**Re: McDonald's at 2000 Gibson Blvd SE  
Erosion and Sediment Control Plan  
Engineer's Stamp Date – 01/10/25 - M15E021G (SWQ-2025-00024)**

Based upon the information provided in your submittal received 5/6/25, the above-referenced ESC Plan cannot be approved until the following comments have been addressed

EROSION CONTROL PLAN

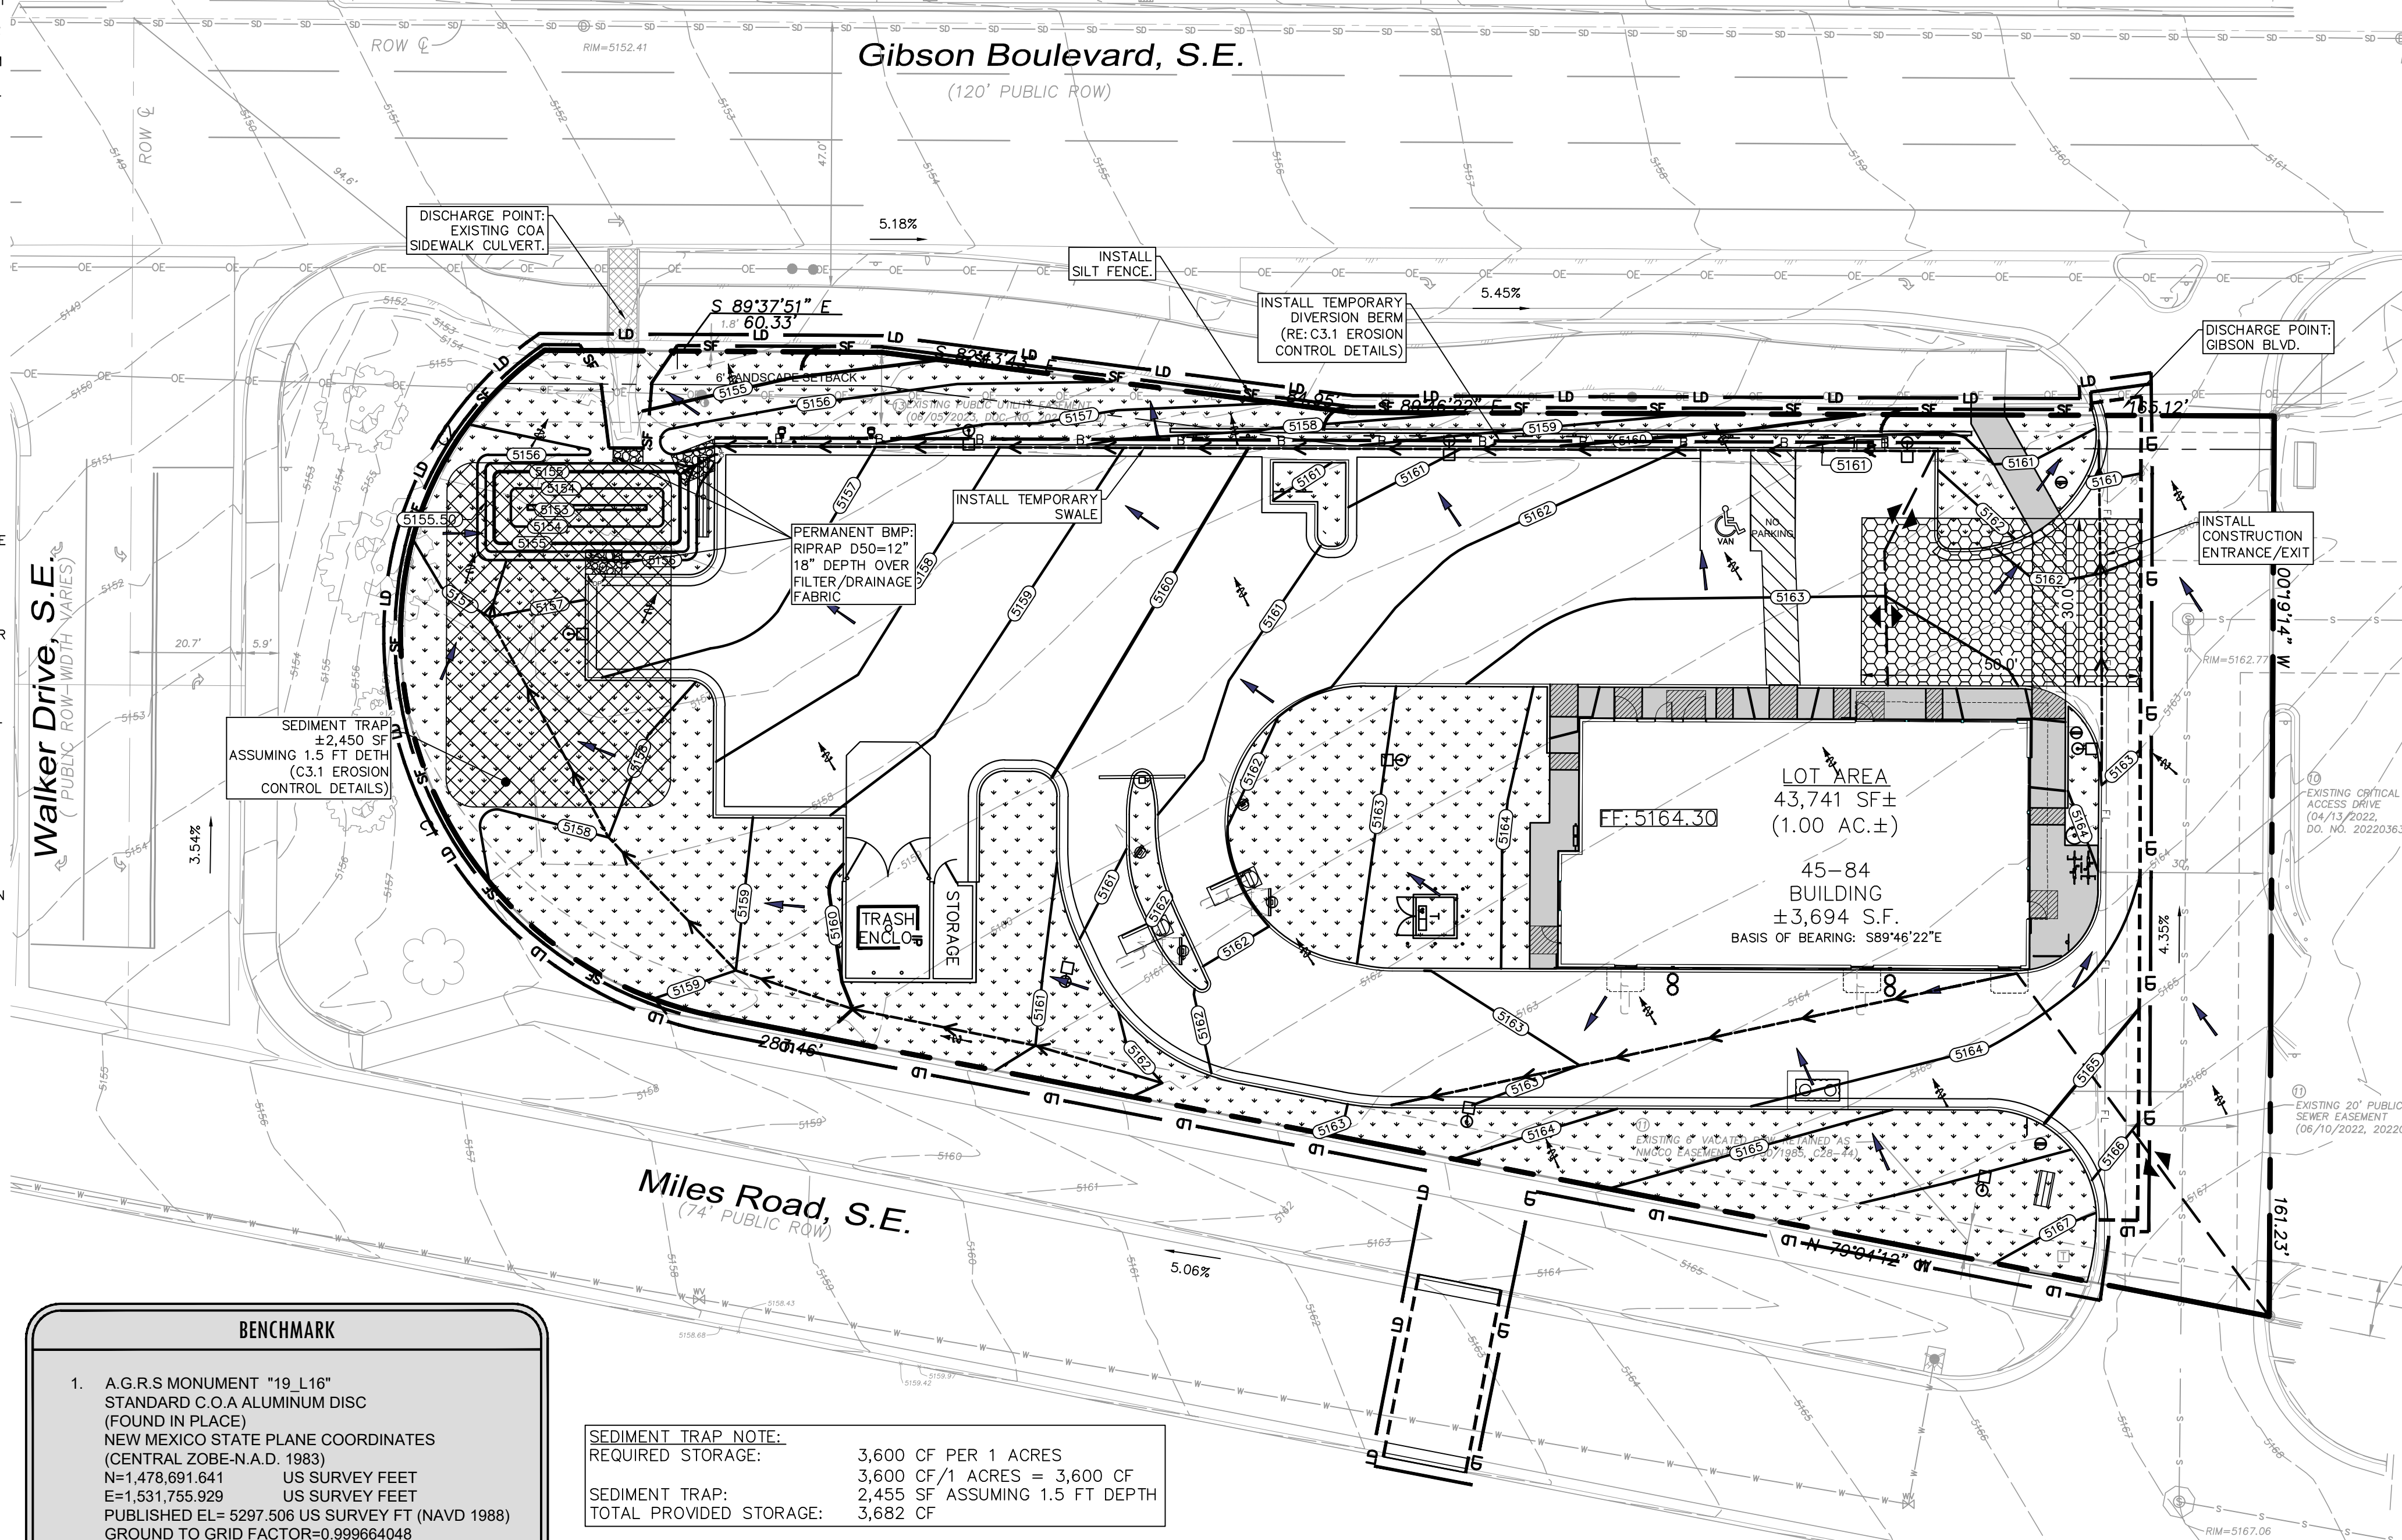
- c. Identify the existing and proposed drainage patterns of this site and its "Discharge Point" per CGP 7.2.4.f.
2. Add a temporary diversion berm to the ESC Plan along the north edge of the proposed parking lot to divert onsite flows into a temporary sediment trap sized to retain 3,600 cubic feet per acre or all of the excess precipitation from the 2-year storm, as per CGP 2.2.12. Add the berm construction to the sequence of construction as one of the first items, simultaneously with the demolition of the existing pavement. Add the removal of the berm to the sequence after the C&G is constructed along the north side of the parking lot.

3. A temporary sediment trap must be constructed upstream of the concentrated discharge point as one of the first items of construction, at the same time as the existing pavement demolition. The temporary sediment trap will be located in the same area as the permanent stormwater quality pond. However, the required size of the temporary sediment basin is based on significantly more precipitation than the permanent pond, so it will require a larger area, potentially overlapping with a portion of the parking lot. Include design calculations, construction details, and specifications for the temporary sediment trap in accordance with CGP 2.2.12 and standard engineering practice per CGP 2.1.2 and CGP 9.6.1 in the ESC Plan resubmittal. Add the sediment trap construction as the first item in the sequence of construction, and its removal as the last item after the rest of the site is constructed and stabilized.
